Subject: Response To Application Number BR/63/19/PL at 15-17 Kew GardensBognor RegisPO21 5RD

TO:	Arun District Council FAO: Stuart Corbey
FROM:	WSCC - Highways Authority
DATE:	12 April 2019
LOCATION:	15-17 Kew Gardens Bognor Regis PO21 5RD
SUBJECT:	BR/63/19/PL Demolition of existing building and erection of 6No. three bedroom dwellings with associated accesses and car parking.
DATE OF SITE VISIT:	
RECOMMENDATION:	Advice
S106 CONTRIBUTION TOTAL:	£ N/a

Project:-			
Proposed Residential Development 15-17 Kew Gardens Bognor Regis West Sussex			
Title:-			
Proposed Site Plan			
Client:-			
Farnden Developments Ltd			
Scale:-			
1:100 (@A1)			
Drawn By:-		Checked By:-	
PJD			
Date:-		Date:-	
14/02/19			
Job.No:-		Drg.No:-	
180037		03

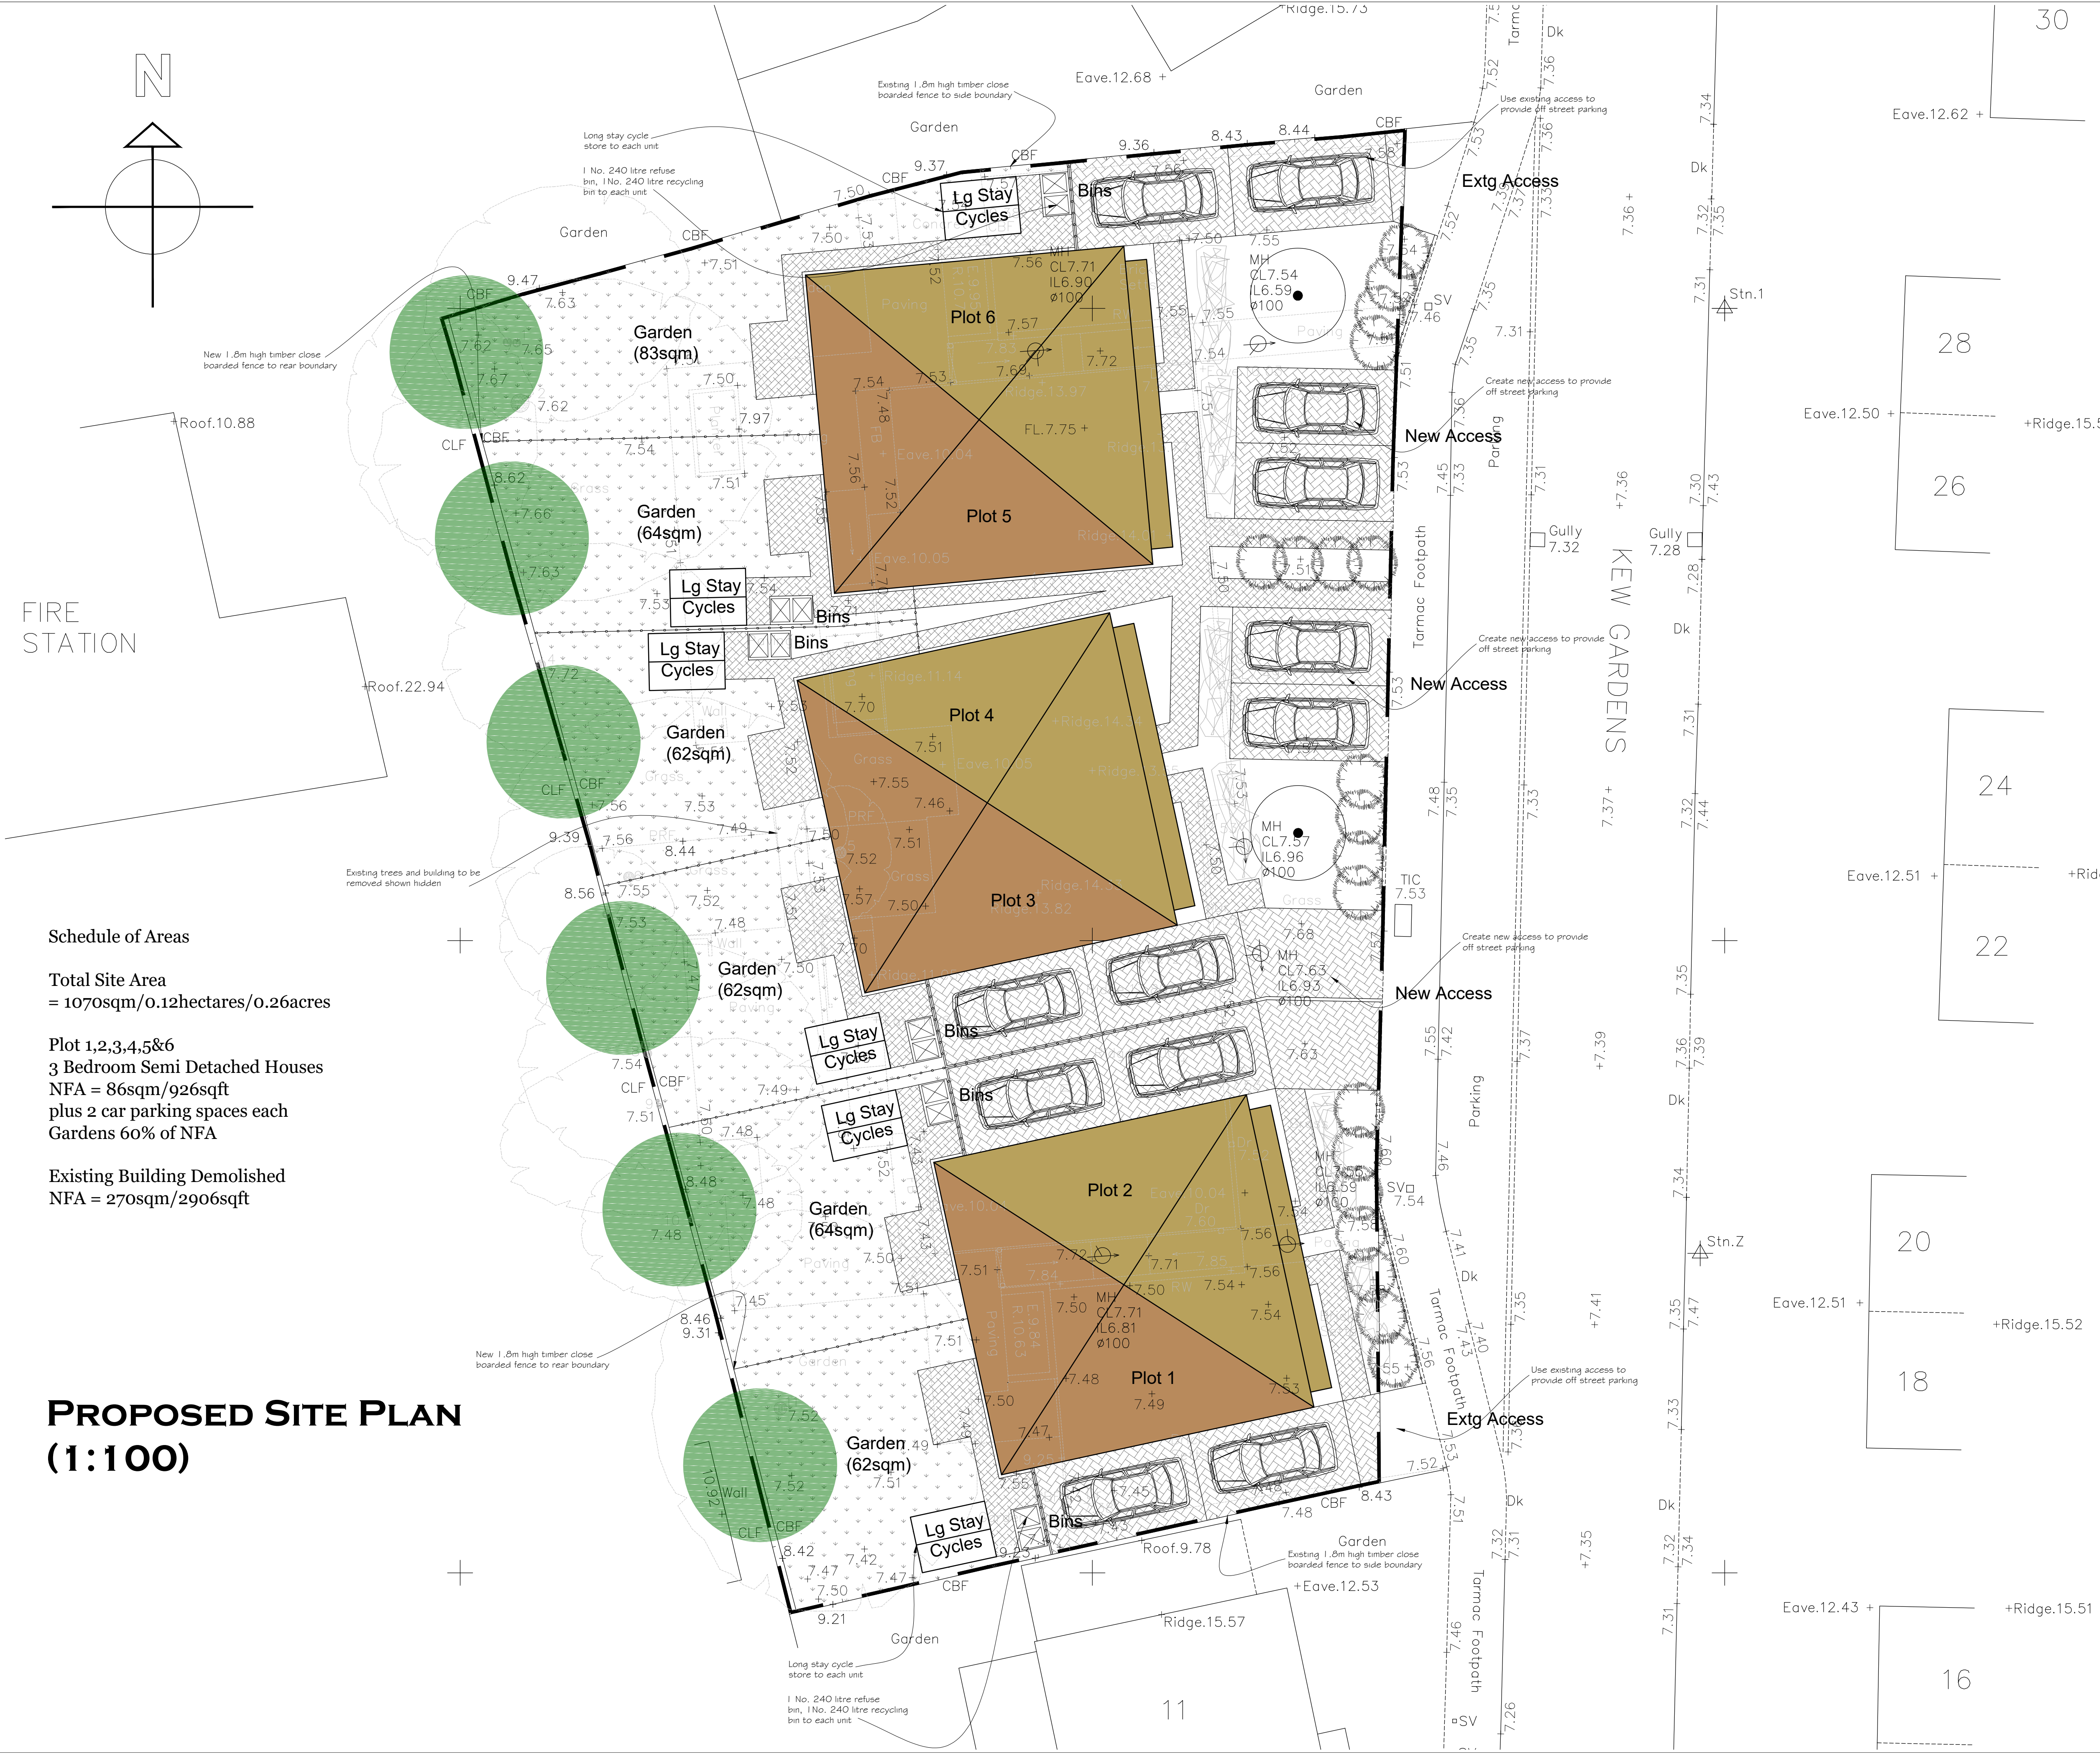
There are no initial concerns with the indicative layout. The parking allocation is anticipated to serve the likely demand generated by the proposals; any overspill parking would be anticipated to be made up via on street parking on the wider network.

A license will be required to carry out the access works onto the publicly maintained highway. I have however discussed the proposed additional Vehicular Crossovers (VCOs) with the Area Highways Manager for Arun, who has advised that applications for VCO's through a layby would likely be *refused* due to the existing parking pressures and the fact that this layby is the only dedicated on street parking location within the cul-de-sac. I advise therefore that for future advice regarding this matter, the applicant liaises with the Area Highways Manager for Arun [REDACTED]

The visibility splays provided are difficult to read as the splay for each access overlaps with the neighbouring visibility splay. A clear revised plan should be provided prior to occupation, which shows the maximum achievable visibility splays from the access point. Due to the fact that Kew Gardens is a no-through road and speeds and vehicle movements are low, this would be anticipated to be sufficient for the use. These splays should be measured 2.4m back from the edge of the highway and span as far as possible to the highway edge on the same side of the road. The splays must intercept only land within the control of the applicant or the highway boundary, the property red edge does not need to include the extent of the visibility splays only the access points.

Similarly the pedestrian visibility splays have not been demonstrated, these are required to be shown 2m back into the site either side of the access and a distance measured along the back of the footway for 2m on each side of the viewpoint.

I acknowledge that the southern and northernmost accesses may not have space to accommodate the entire 2m x 2m splay due to the proximity with neighbouring properties; therefore it is advised that these are provided to best of ability within land under the control of the applicant.

No part of the development shall be first occupied until such time as the vehicular access serving the development has been constructed in accordance with the details shown on the drawing titled Access Plan & Visibility Splays and numbered 06.

No part of the development shall be first occupied until maximum visibility splays shall be provided at the site access onto Kew Gardens in accordance with a plan to be submitted to and approved by the planning authority. These splays shall thereafter be kept clear of all obstructions to visibility above a height of one metre above the adjoining road level.

No part of the development shall be first occupied until pedestrian visibility splays of 2 metres by 2 metres have been provided or to best of ability either side of the proposed site vehicular access onto Kew Gardens in accordance with plans and details to be submitted to and approved in writing by the Local Planning Authority. These visibility splays shall thereafter be kept free of all obstructions over a height of 0.6 metre above adjoining carriageway level or as otherwise agreed.
